**Consultation Response from KC,  
Highways Development Management**

**2020/92546 Land off, Blackmoorfoot Road and Felks Street, Crosland Moor, Huddersfield, HD4 7AD**

**Date Responded:  
02/12/2020**

Z:\projects\1852 Former Fireworks Factory, Huddersfield\CAD\Croft Drawings\1852-F01-F02.dwg

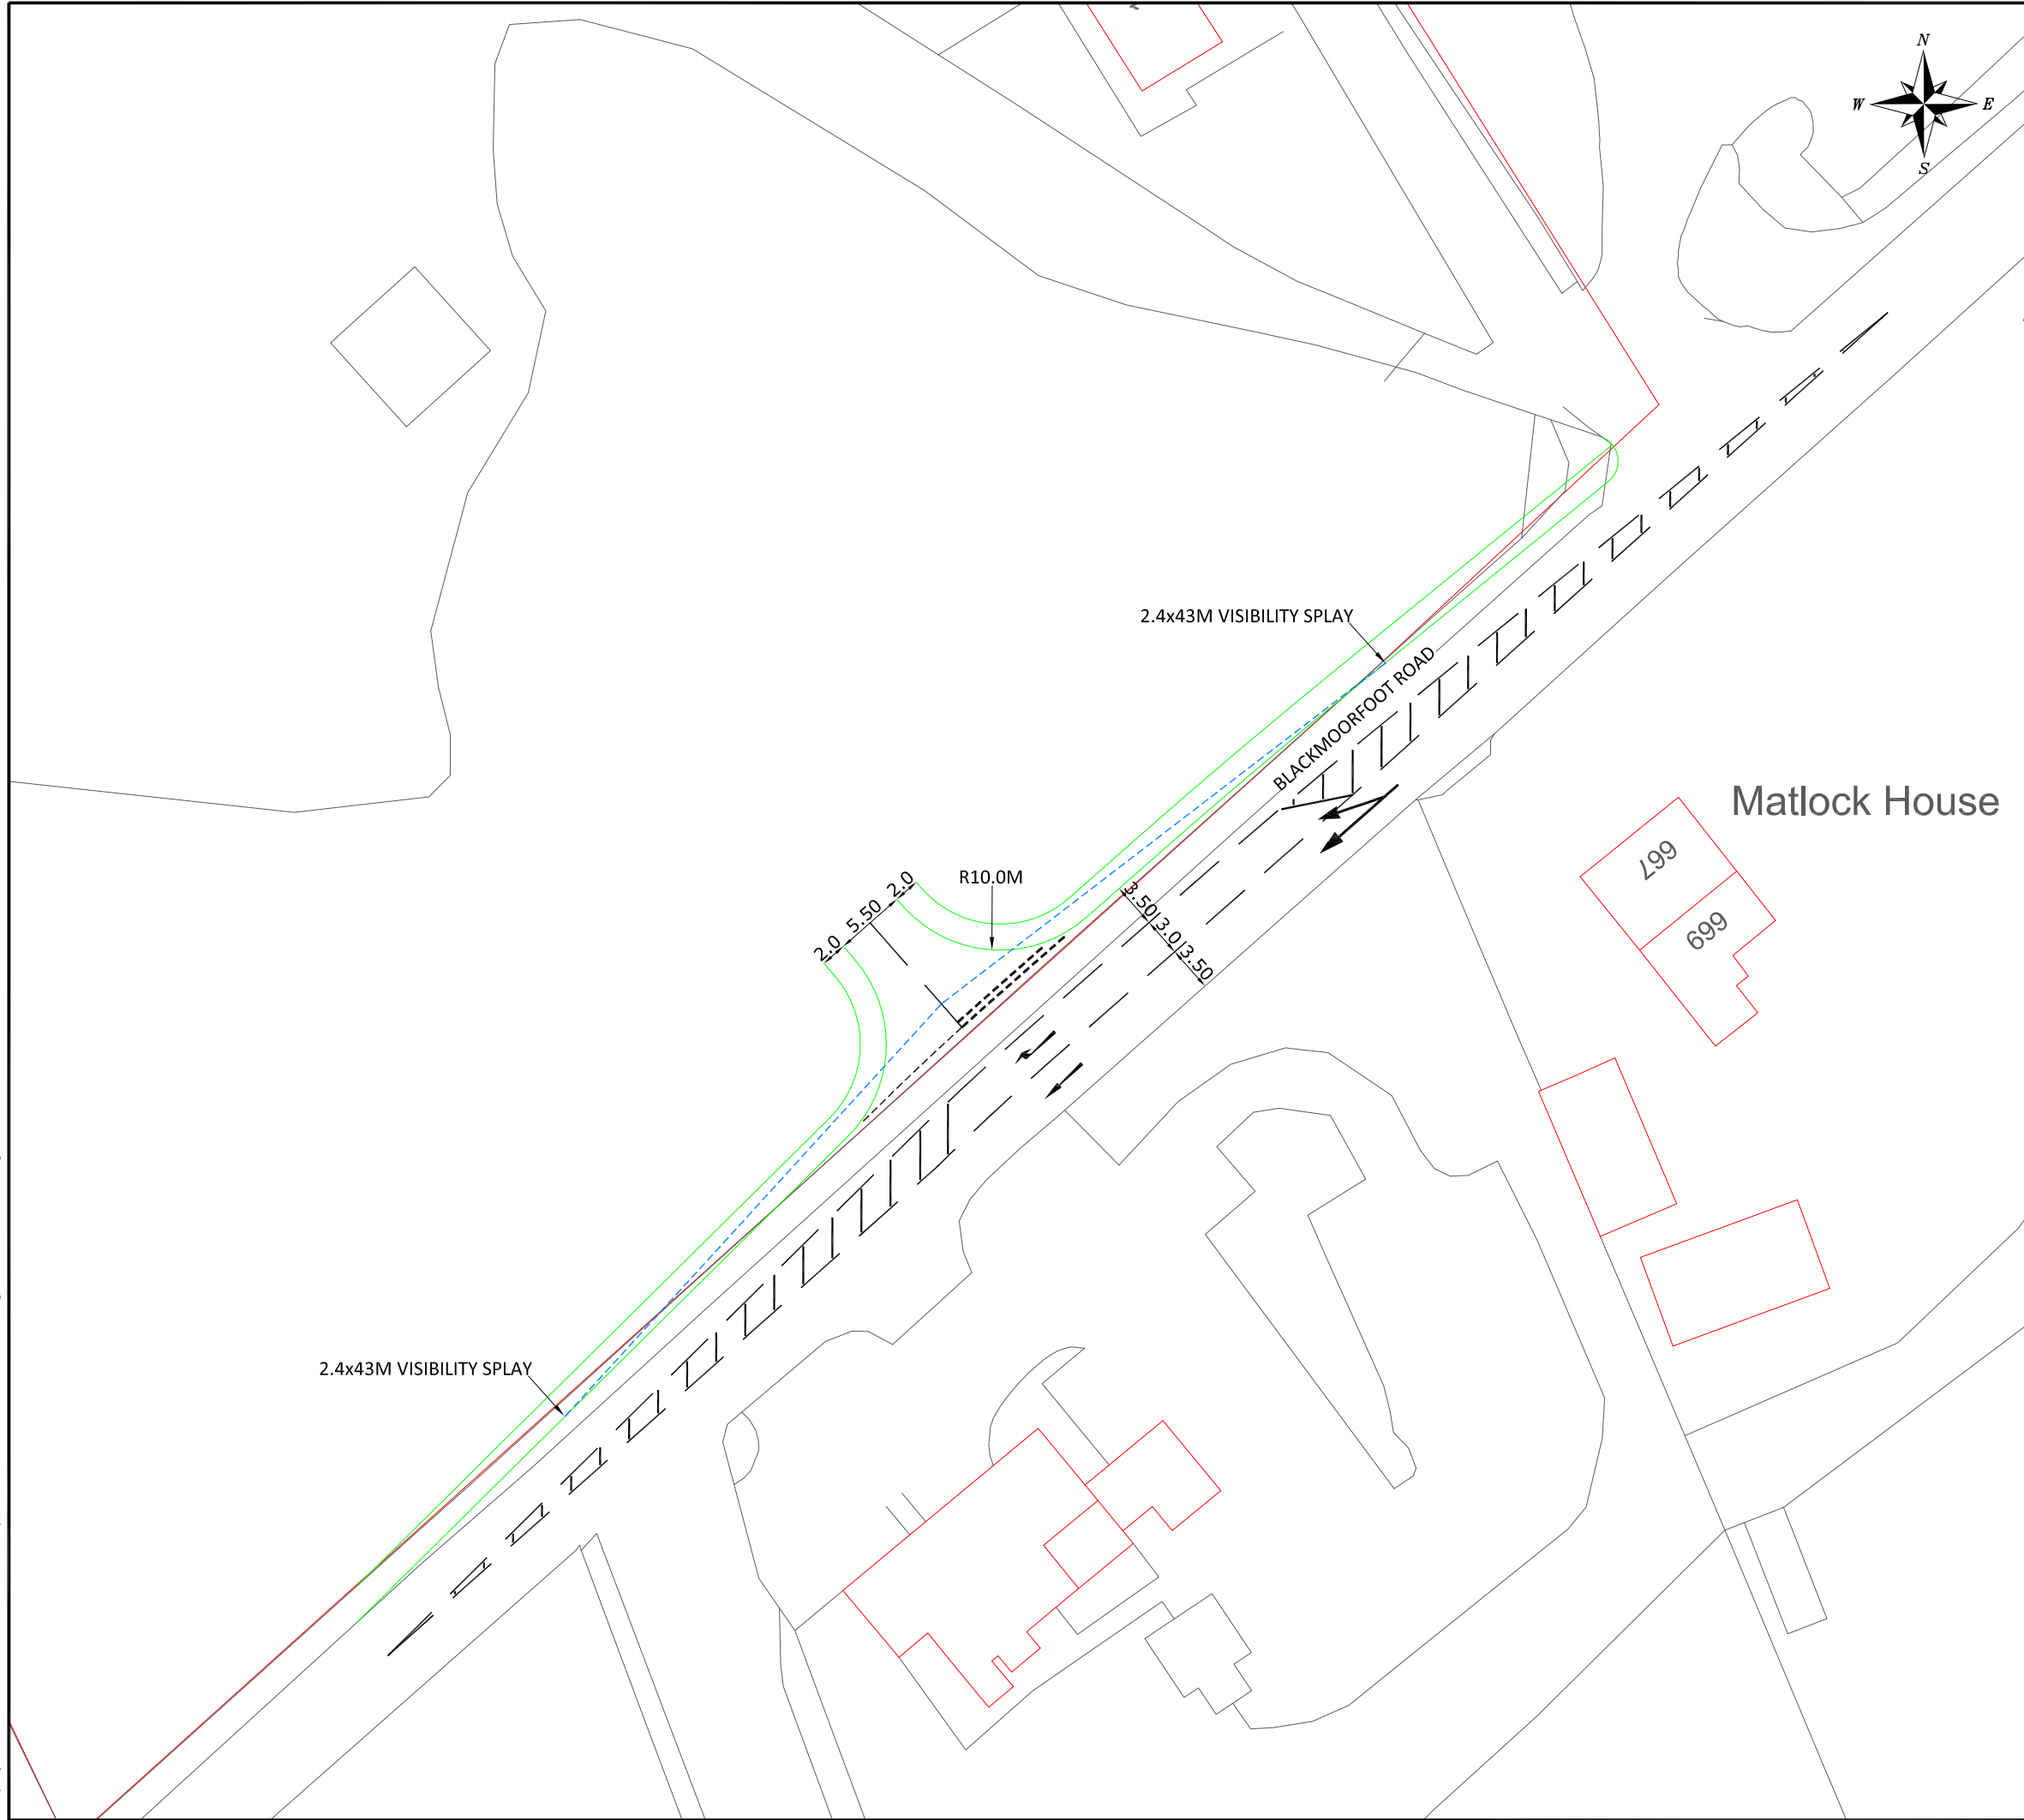
Contained within the Transport Assessment is a plan which identifies a potential site access of Blackmoorfoot Road (dwg ref 1852-F01). The proposed site access should be of a minimum road width of 6.75m plus cycle lanes to both sides and 2m footways.

Footways to the site frontage should be of a minimum 2m in width.

The existing 30 mph speed limit will need relocating to beyond the site access on Blackmoorfoot Road to facilitate suitable sightlines for the development, this will need to be secured via suitable condition accordingly.
